From: Sue Howell
Sent: 03 May 2018 14:48
To: Planning.Responses
Cc: Simon Davis
Subject: RE: Planning Consultation on: BR/35/18/PL

Comment from Greenspace

APPLICATION BR/35/18/PL

Site Address: Car Parking Site Adjacent to 112 Gravits Lane
Bognor Regis PO21 5LW

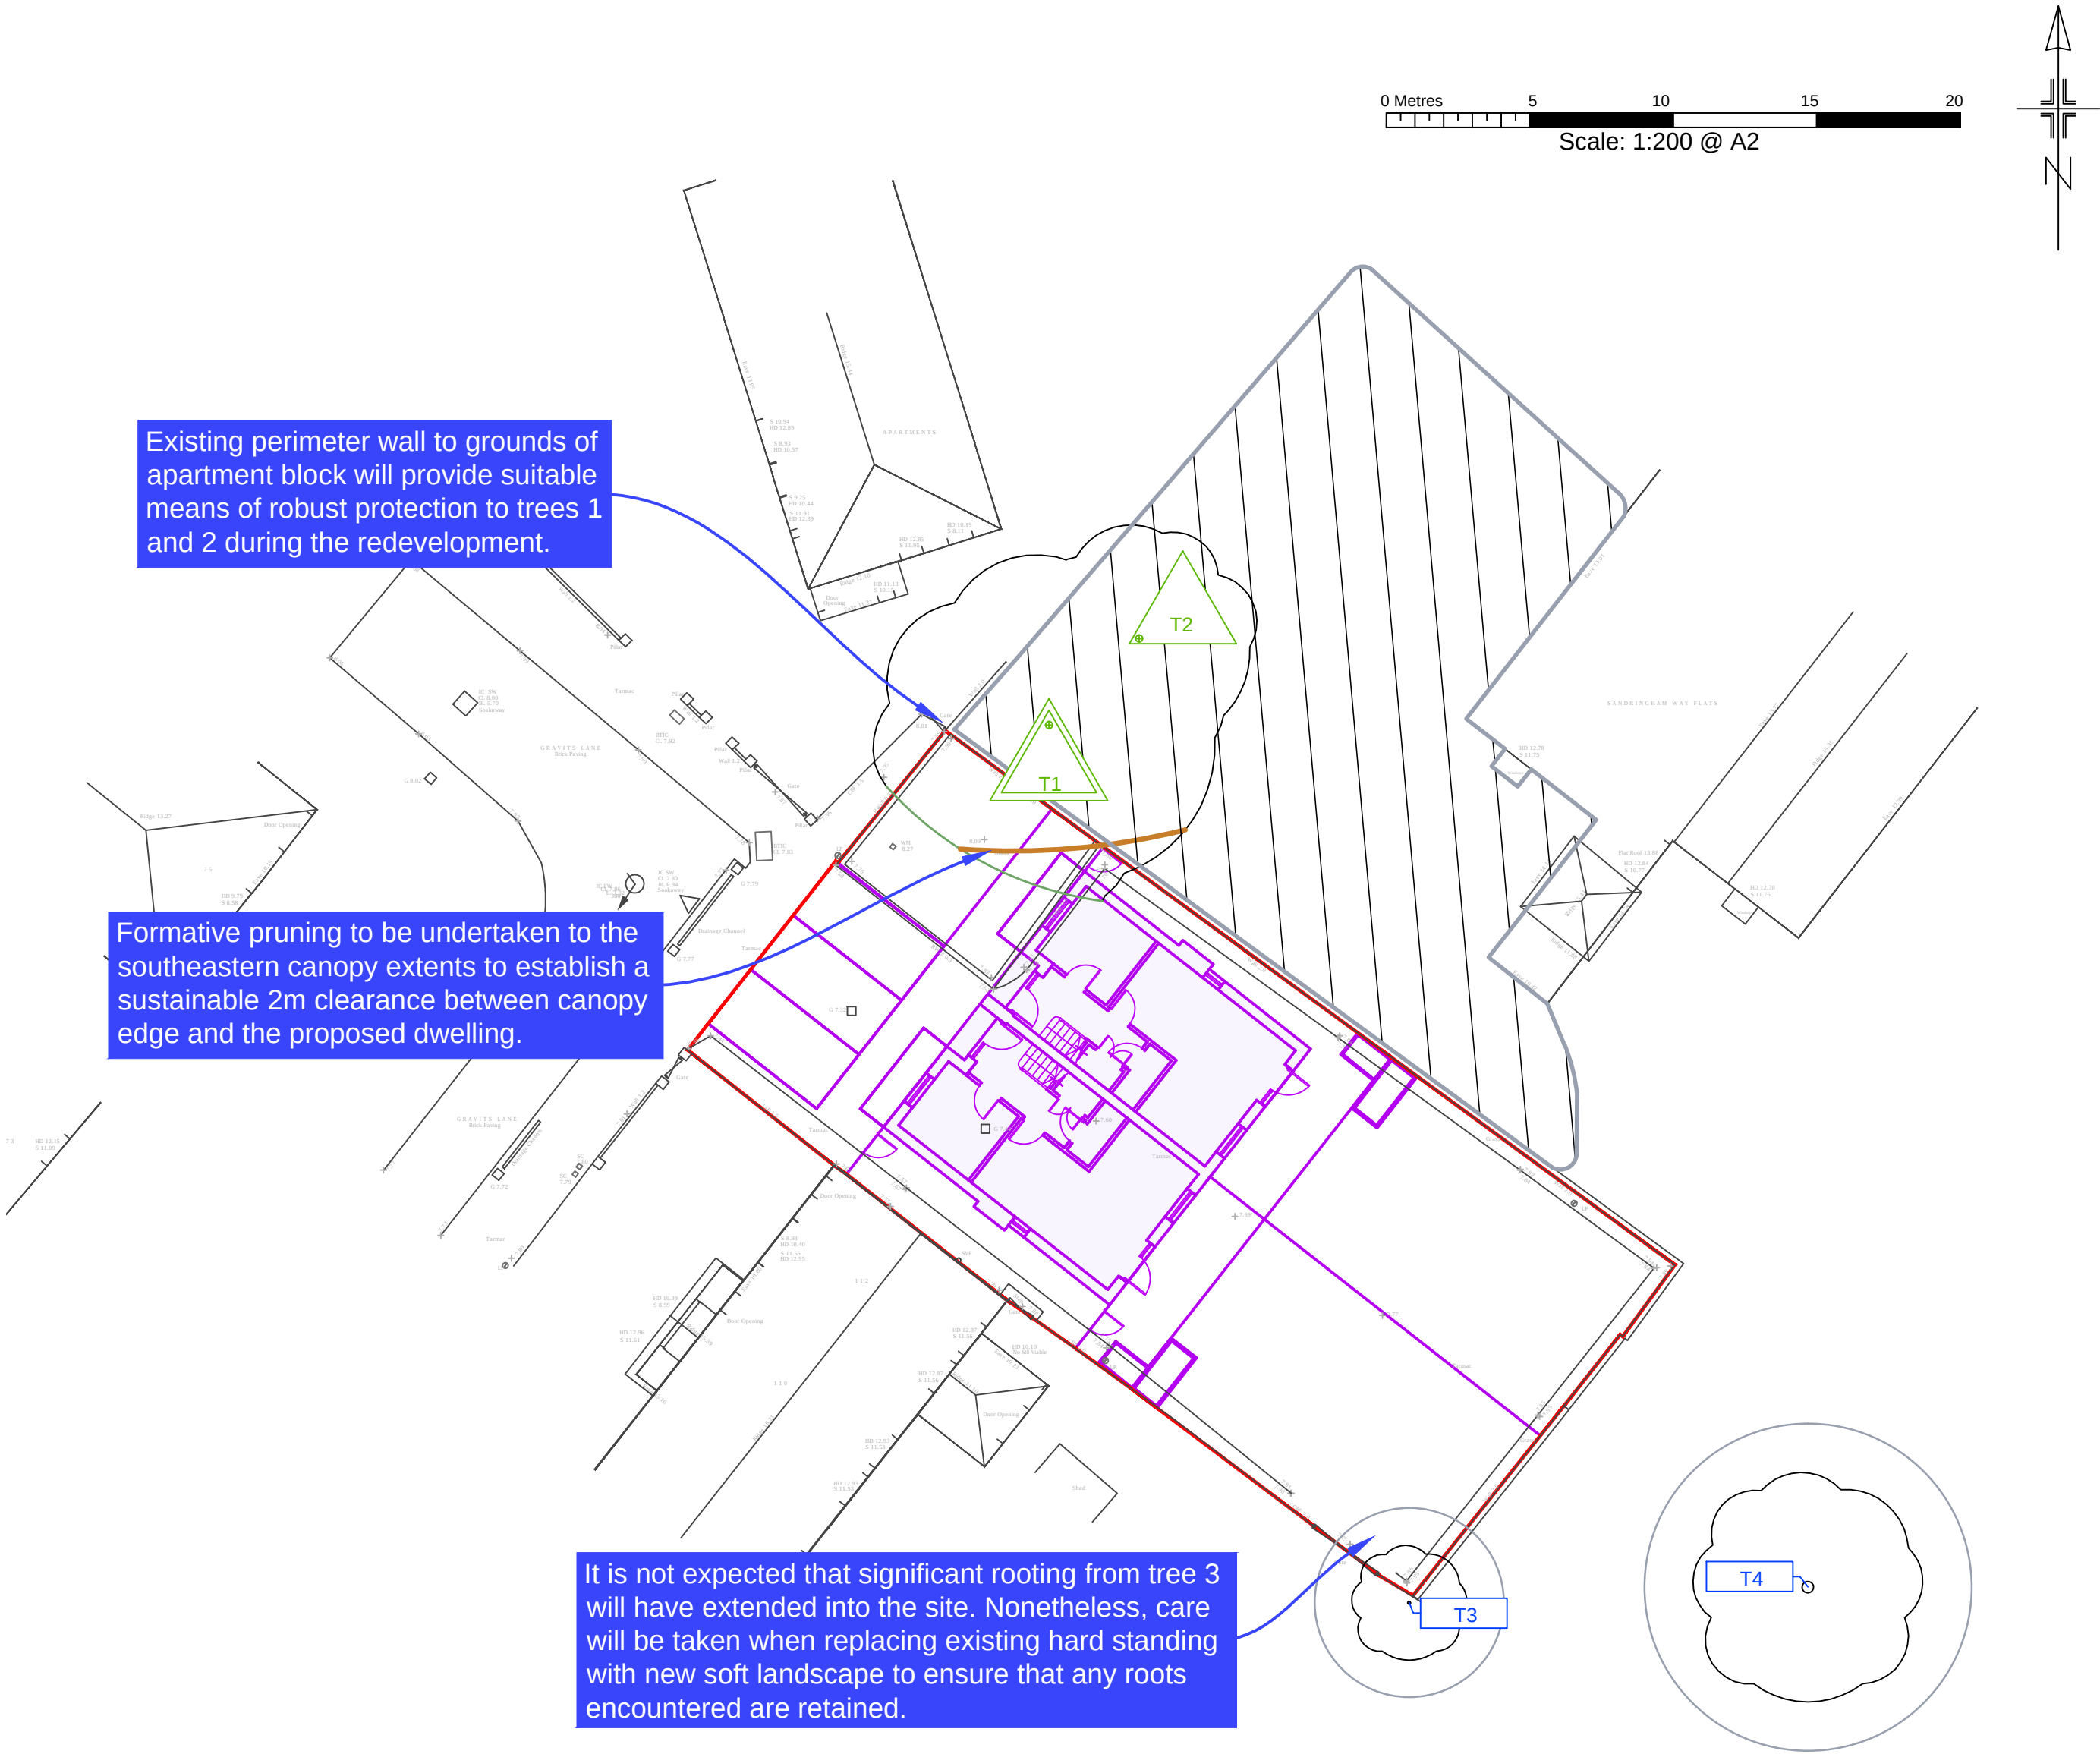
The to be retained existing periphery trees, must be protected during construction, and consideration given to root protection areas.
